Belinda Scott  
Senior Planning Officer  
Transport Assessments  
Department of Planning, Industry and Environment

Re: Northern Beaches Link potential project .  
Incorrect totals and labelling.

Figure 3-4 Forecast change in weekday traffic volumes average (two-way) in the AM peak on key Northern Beaches corridors by 2037

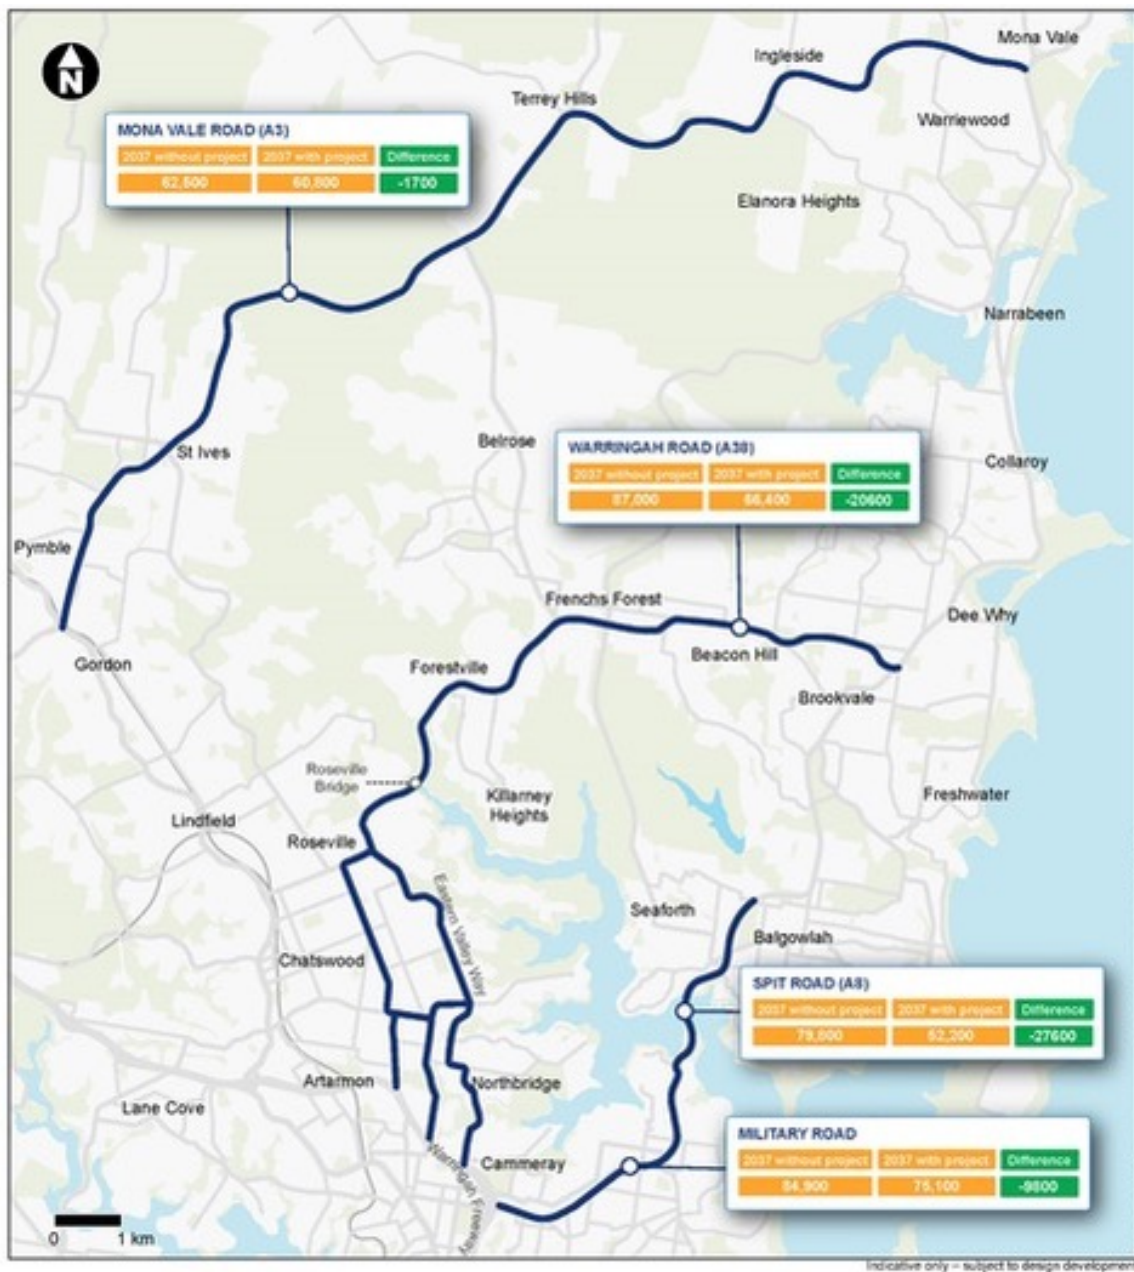
1. Total trips refers to vehicle numbers and not passengers. (See 4-4).
2. 'Figure 3-4 Forecast change in weekday traffic volumes average (two-way) in the AM peak on key Northern Beaches corridors by 2037'.

' The Correct label should read: *Figure 3-4 Forecast change in ~~average~~ weekday traffic volumes ~~average~~ (two-way, ~~daily~~) ~~in the AM peak~~ on key Northern Beaches corridors by 2037*' according to Tim Kwok.

If we look at figures of Figure 3-4 the numbers shown refer to vehicle trips and not passengers numbers.
